Application 3/2011/0580
Whalley Community Hydro

A Dowd
6 January 2012

Whalley Community Hydro Completed Scheme	
Sheet	6/7
Drawn by	
Checked by	<i>GH Lower</i>

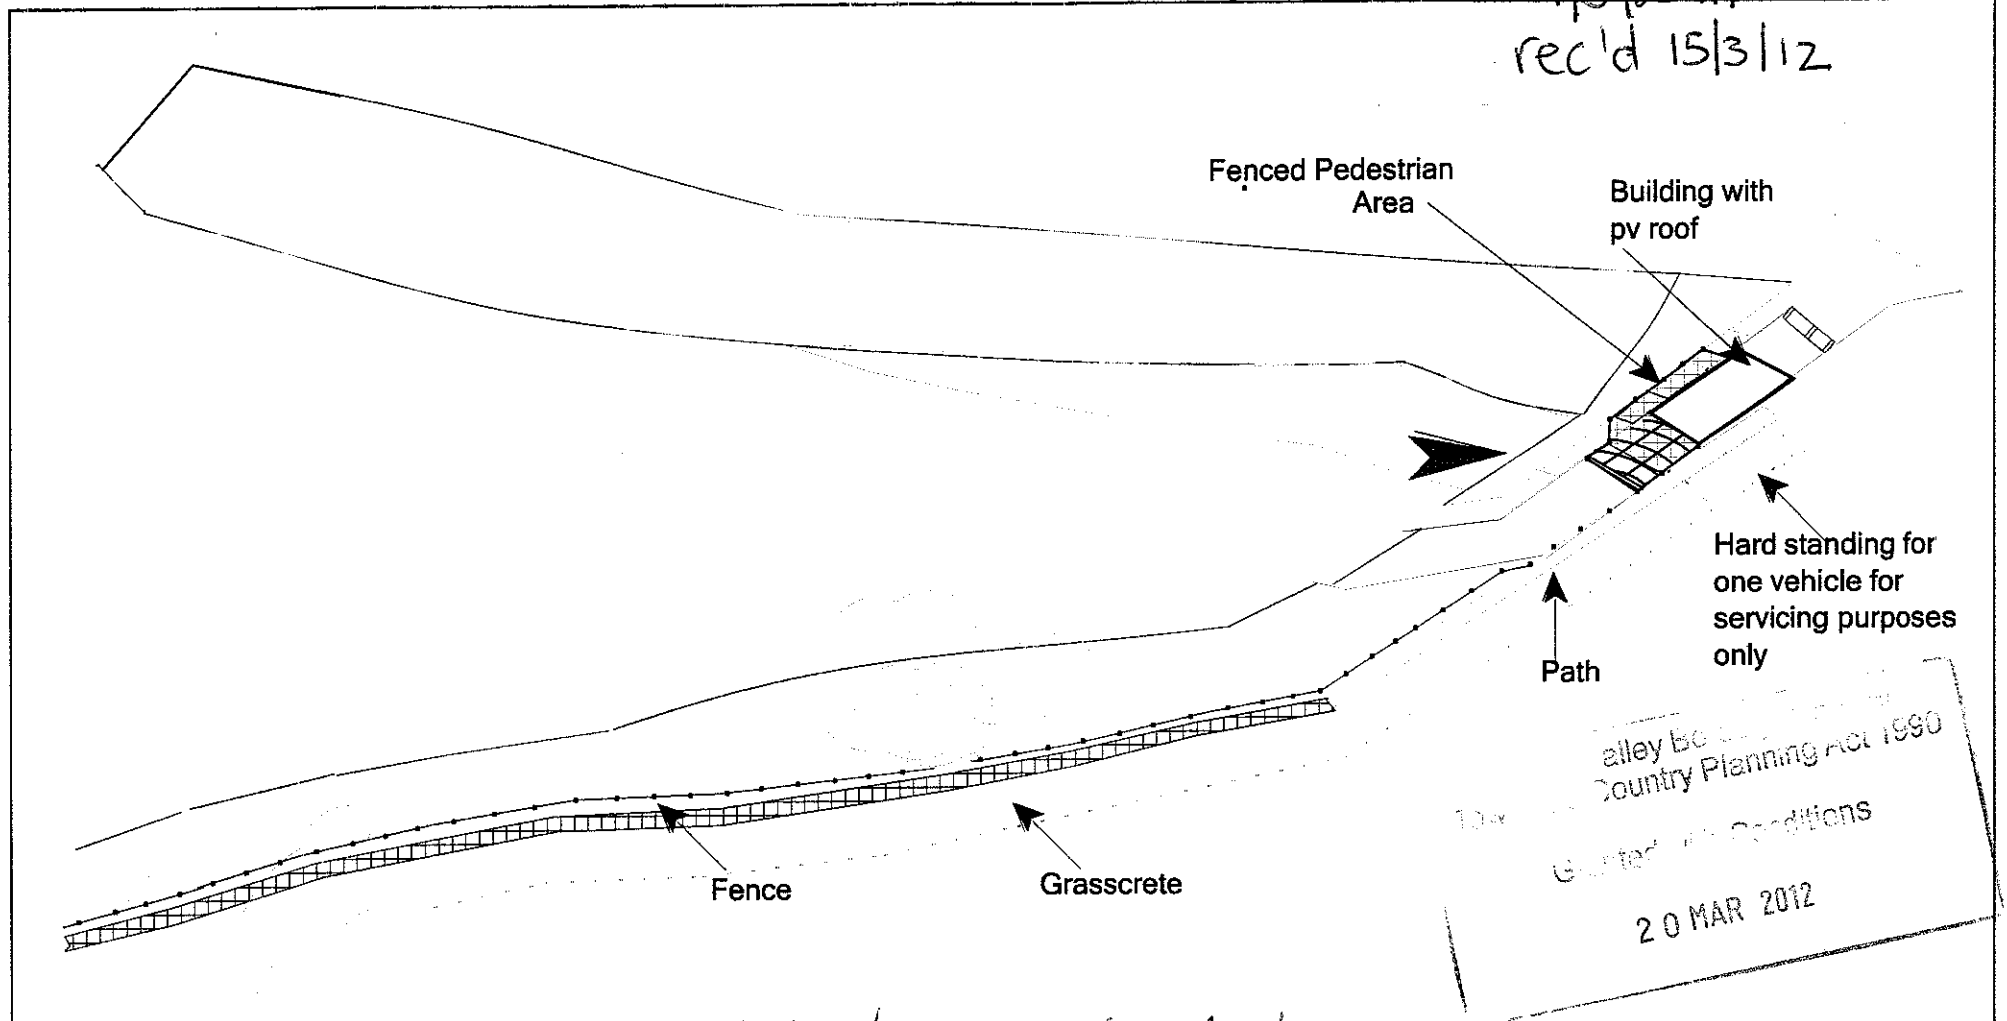
In my opinion, the proposal would be conspicuous, incongruous and visually intrusive because of its size (the study centre and fenced pedestrian area would appear unnecessary) and design (asymmetric roof covered in solar panels; the fencing, formal accessway and hardstanding would appear unnecessary). This would be unduly harmful to the character, appearance and significance of the settings to Whalley Conservation Area and The Marjorie (Grade II listed) and of the important views from Whalley Bridge and Calder Vale within Whalley Conservation Area to the countryside beyond. This would be contrary to Policies ENV16 and ENV19 of the Ribble Valley Districtwide Local Plan.
